Department of Planning and Environment

STATE SIGNIFICANT DEVELOPMENT (SSD) 12469087 – THE GUNLAKE QUARRY CONTINUATION PROJECT - RESPONSE TO SUBMISSIONS

TfNSW has completed a review of the information provided, including the *Gunlake Quarry Continuation Project Submissions Report* prepared by EMM dated 14 March 2022, while focusing on the impact to the state road network.

APPENDIX 3: PRIMARY AND SECONDARY TRANSPORT ROUTE

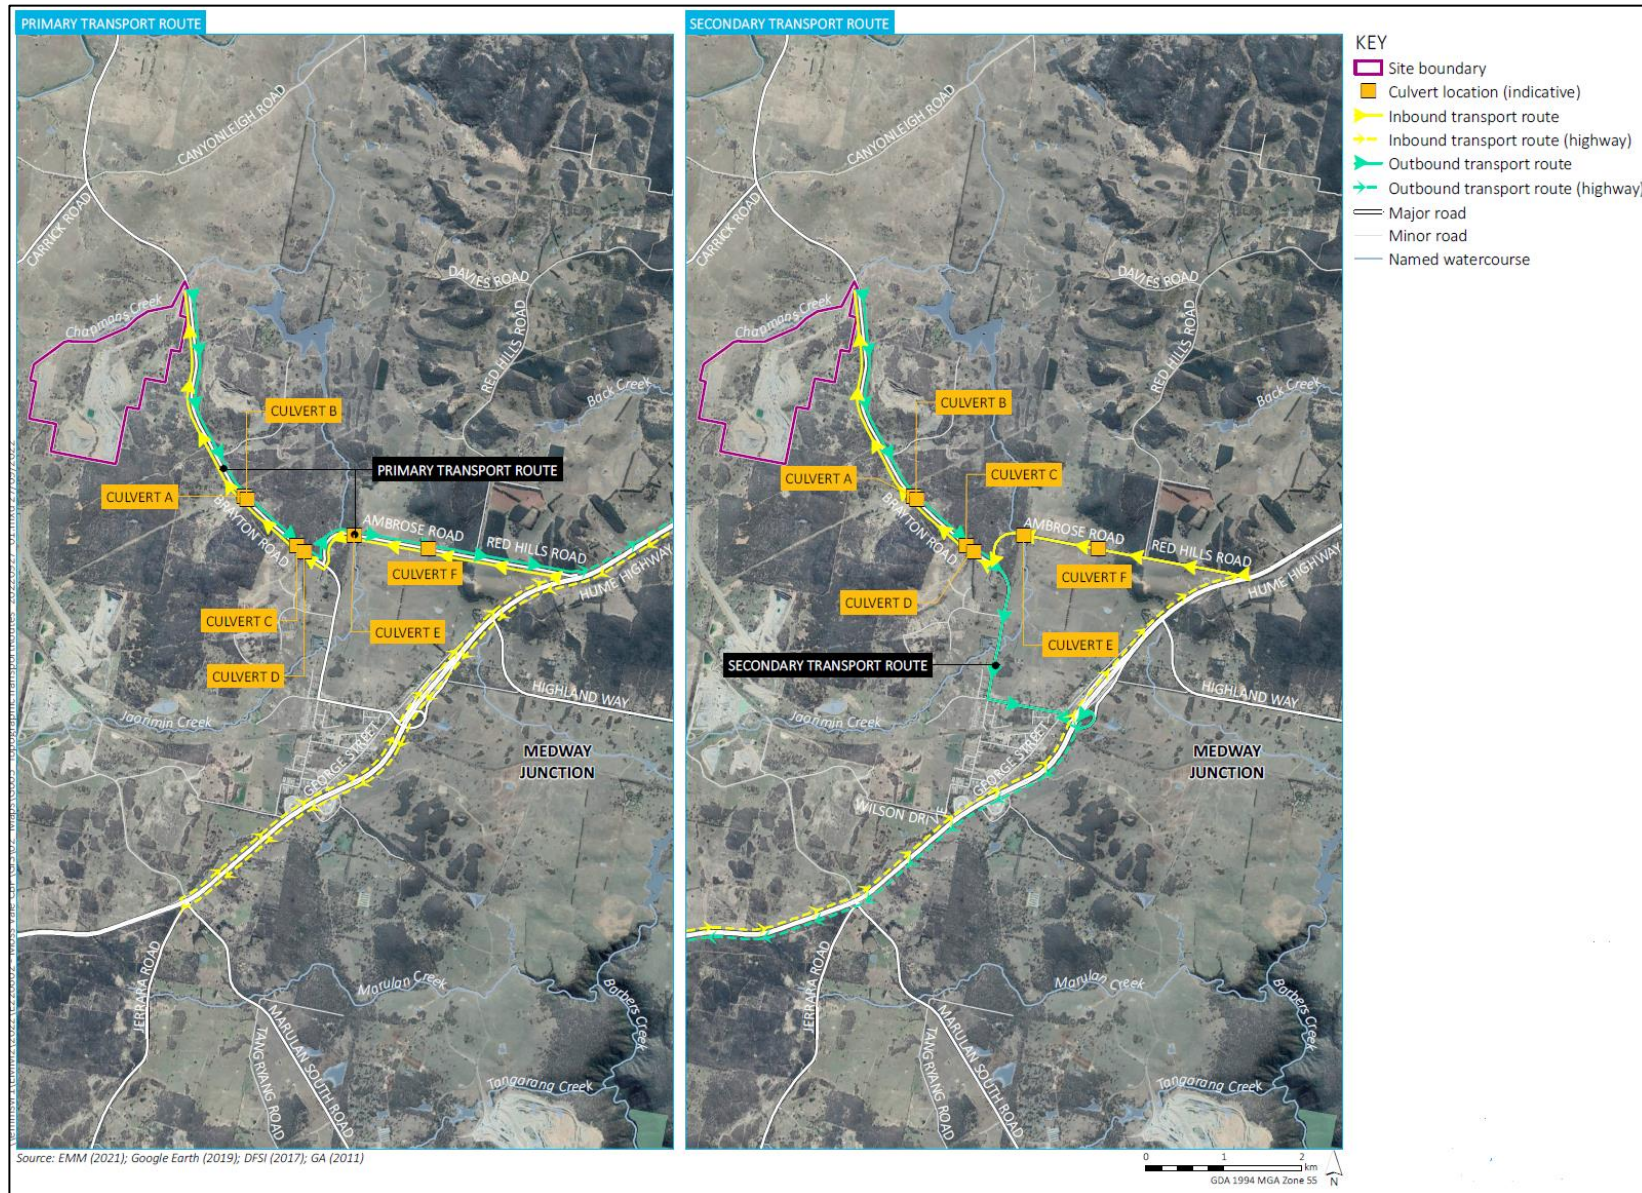
- the key state road is the Hume Highway to which the site has access via the local road network (e.g. Red Hills Road) when using the primary transport route (refer to **Attachment 1**);

TfNSW notes that all access to the site for heavy vehicles will be gained via the intersection of Red Hills Road and the Hume Highway. TfNSW also notes that the current SSD application will result in an increase in heavy vehicles using this intersection to access the development site.

In its letter dated 3 December 2021, TfNSW sought details on “*Measures that will be implemented to stop/prevent vehicles departing the Hume Highway via Red Hills Road cutting the corner (southern side of the Red Hills Road/Hume Highway intersection) and damaging existing infrastructure within the road reserve (e.g. existing pits, etc)*”. The cutting of this corner is evident in the Google image provided in **Attachment 3**. The response provided by the applicant to the above concern was “*Gunlake notes that TfNSW has a responsibility to maintain, and if required improve, this intersection*”.

TfNSW does not believe the above response is appropriate noting the number of heavy vehicles that this SSD application will generate turning left into Red Hills Road at this intersection (i.e. maximum of 375 inbound movements). TfNSW should not be left maintaining/repairing damage done as a result of larger vehicles traversing outside the painted edge line. As such, TfNSW believes that the proponent must identify measures that will be implemented to stop/prevent heavy vehicles departing the Hume Highway via Red Hills Road cutting the corner and damaging existing infrastructure within the road reserve such as pits, guide posts, etc. The above will require a concept design for what is being proposed to be submitted to TfNSW for review and approval.
